From: Anita Gardner
Sent: 12 November 2018 15:35
To: Karen Parsons
Subject: FW: R/204/18/PL Springfield House
Attachments: 05A Elevations .pdf; 07 Section.pdf

Drawing Name
Location & Block Plans

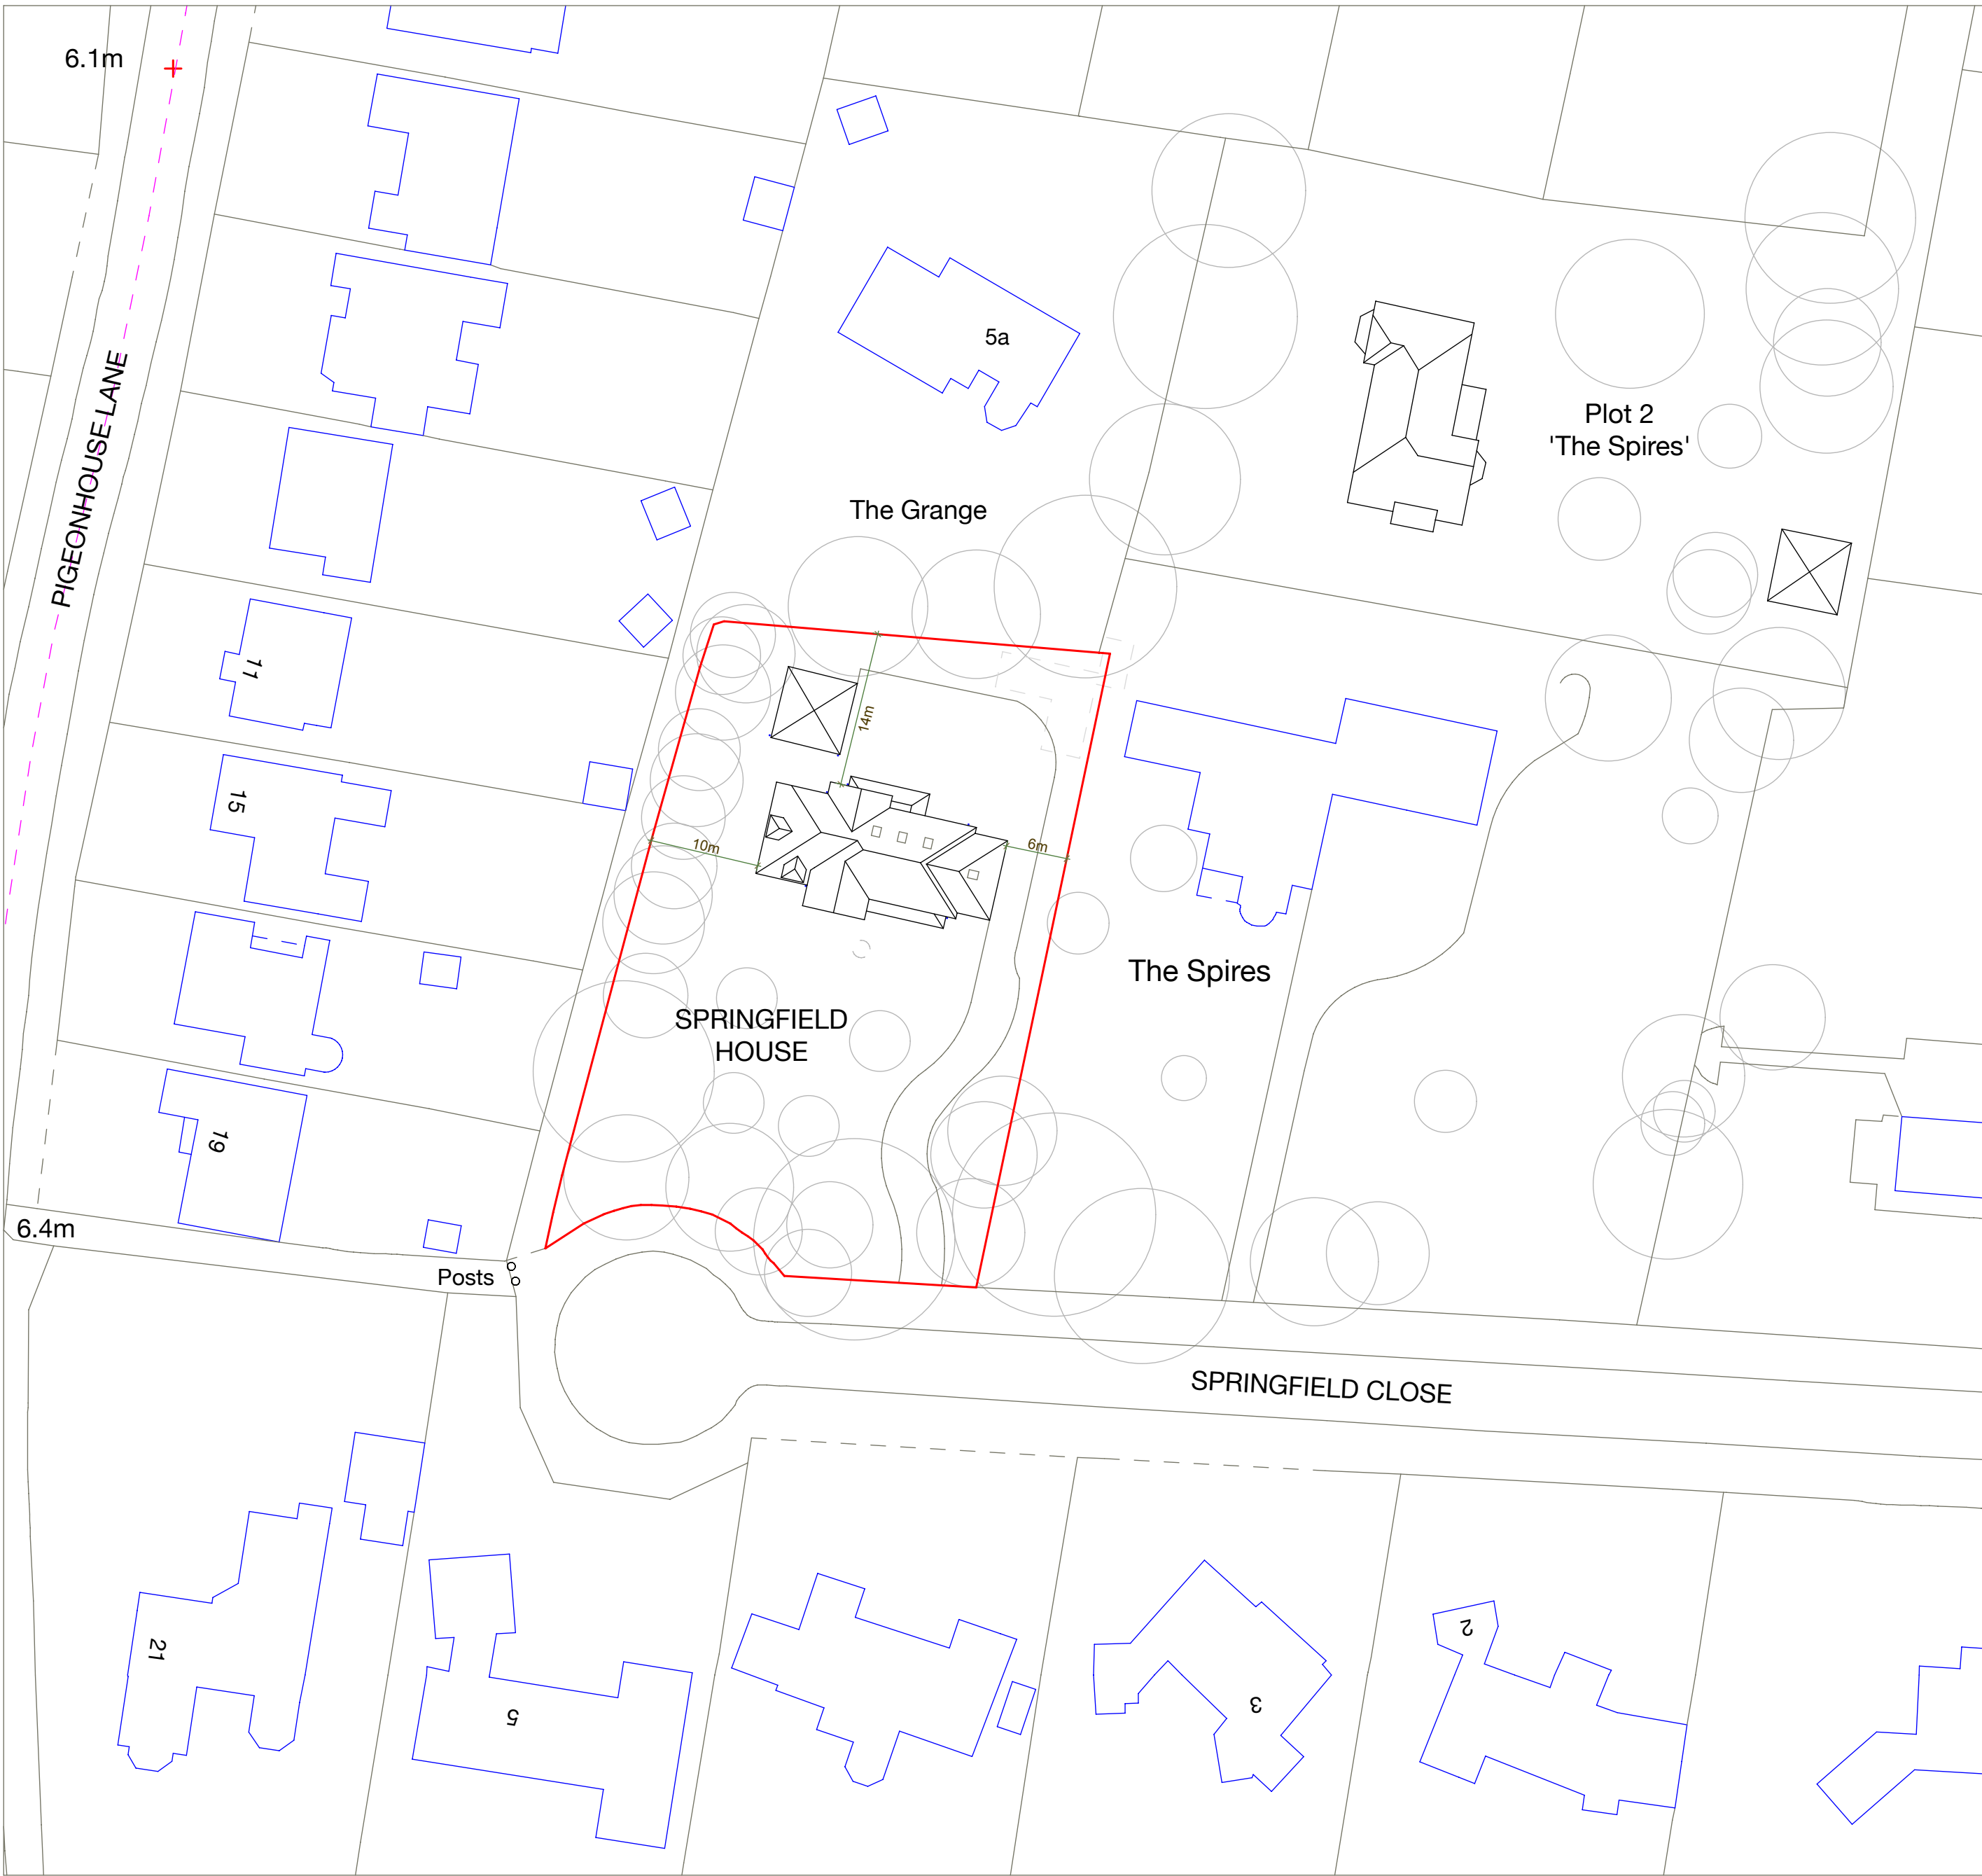
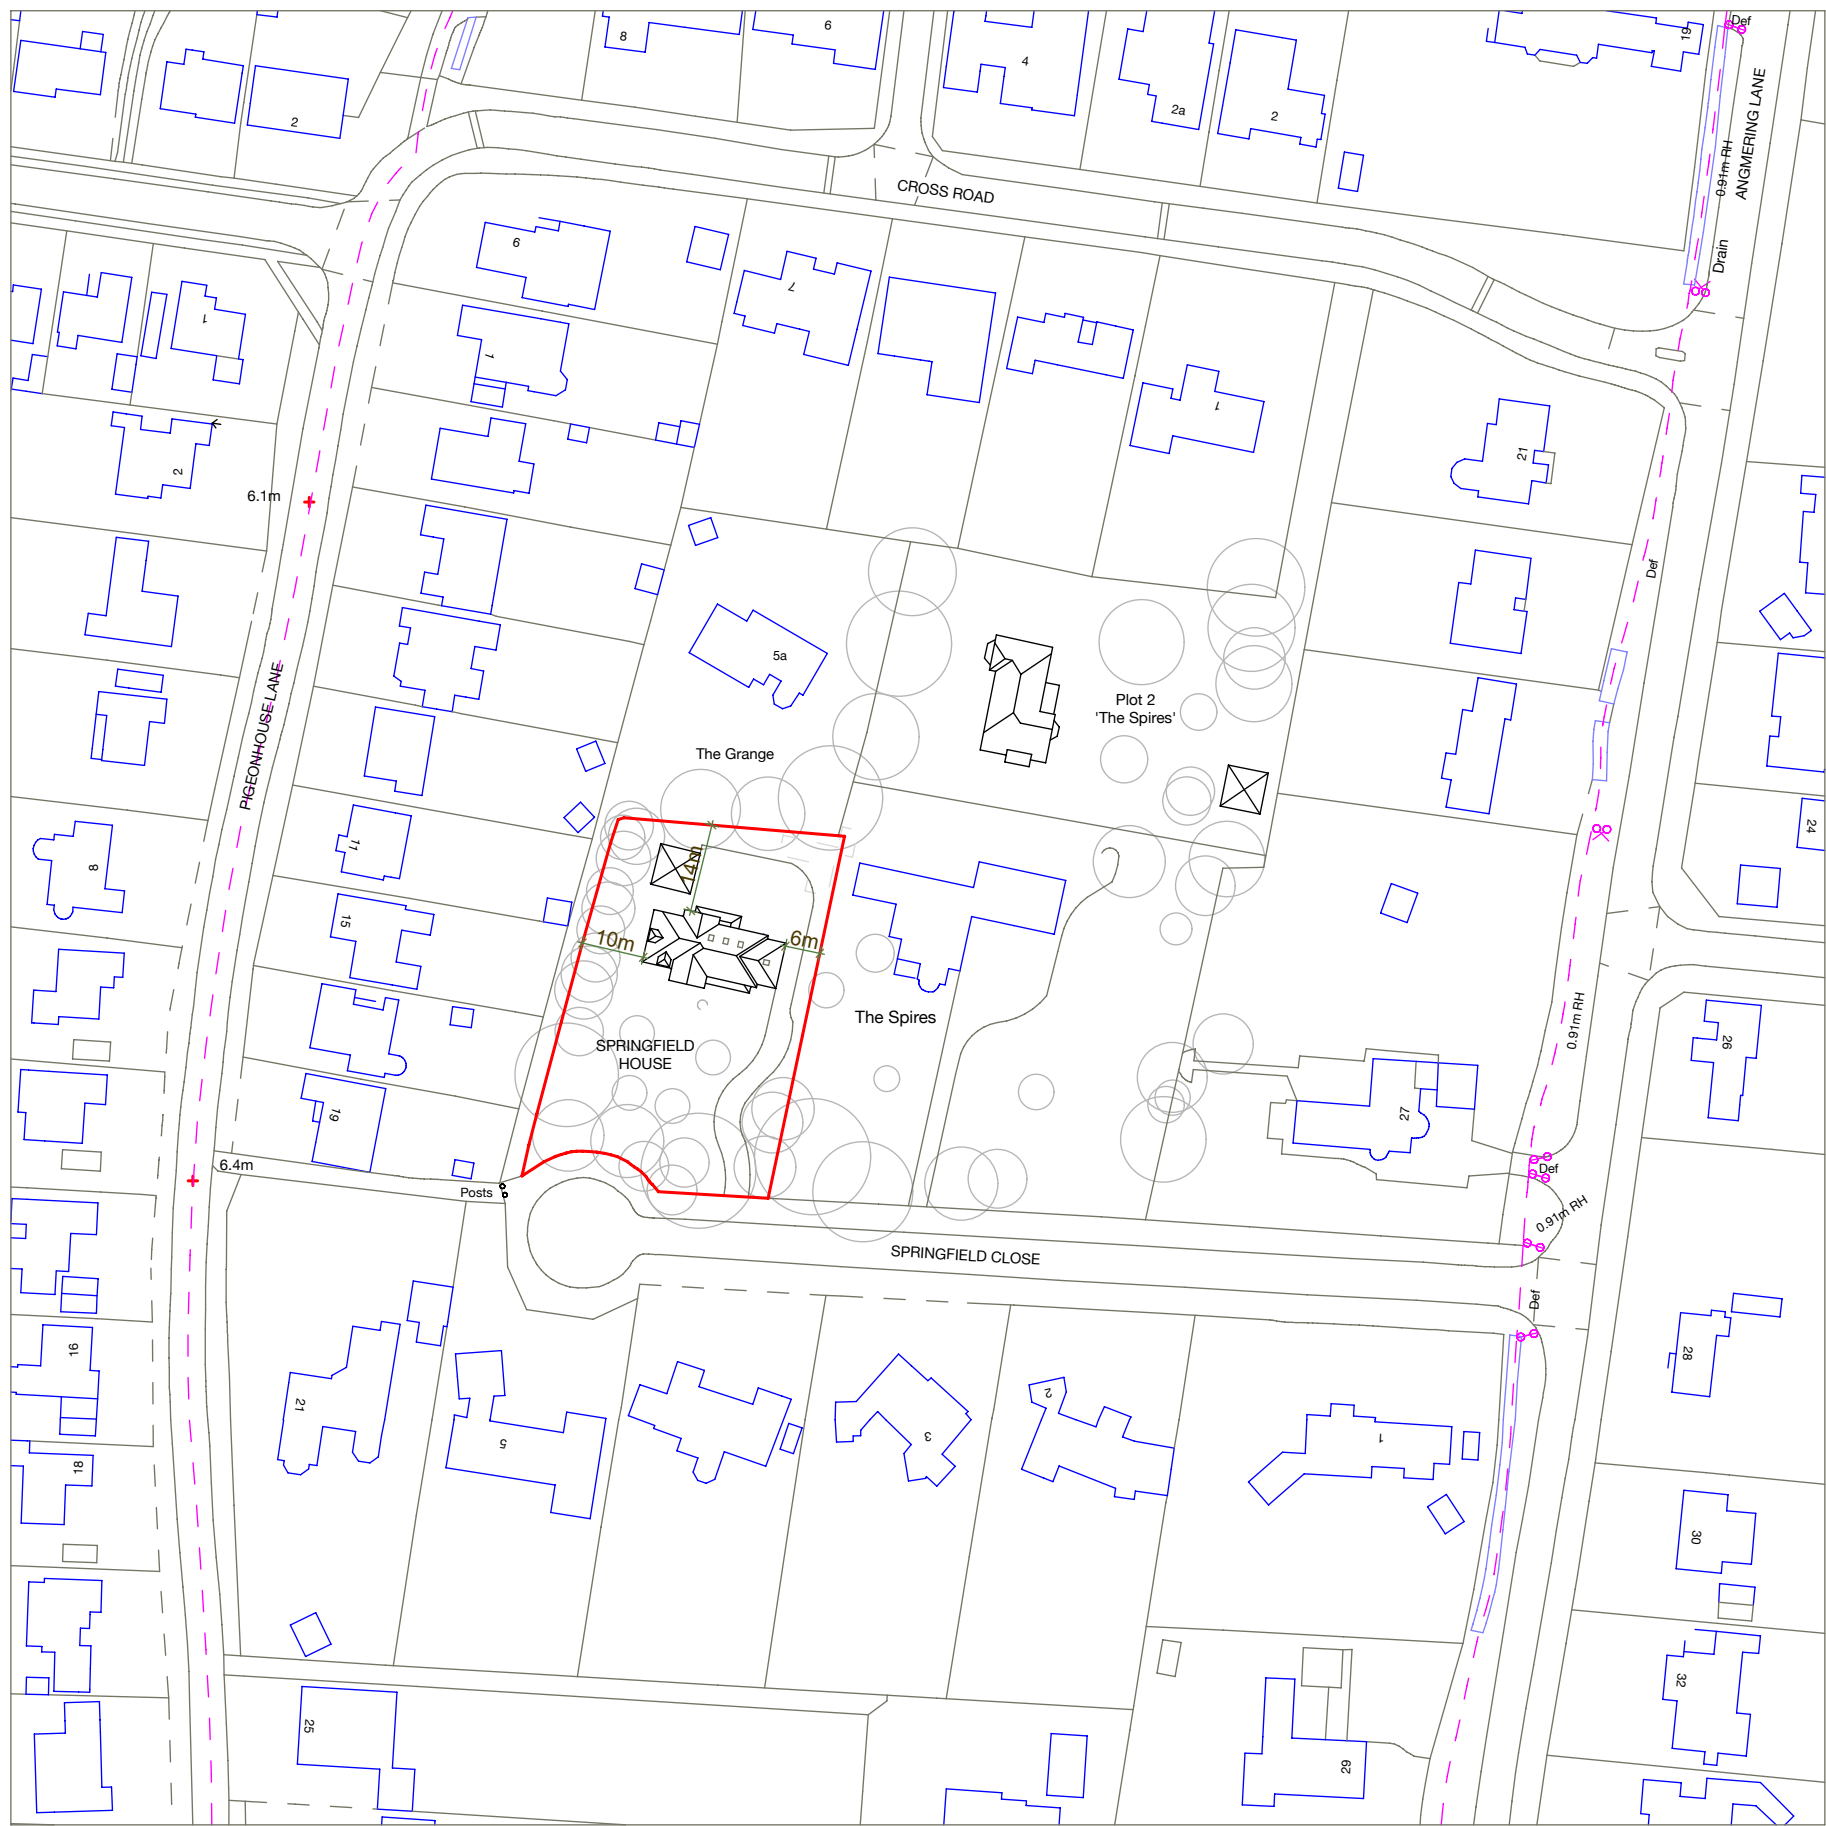
Can I also clarify with you that the dwelling has been increased in length by 1m resulting in a reduction in distance to the eastern boundary of 1m? This is not included in the items listed in part 23 of the application form. This 1m reduction may result in the imposition of an obscure glazing condition to the en-suite windows at first and second floor in the side elevation.

I can confirm that the originally consented building's length has increased by 1m to the East, therefore reducing the distance of the East Elevation to the boundary from 7m to 6m as noted on the Location and Block plans drawing 06.
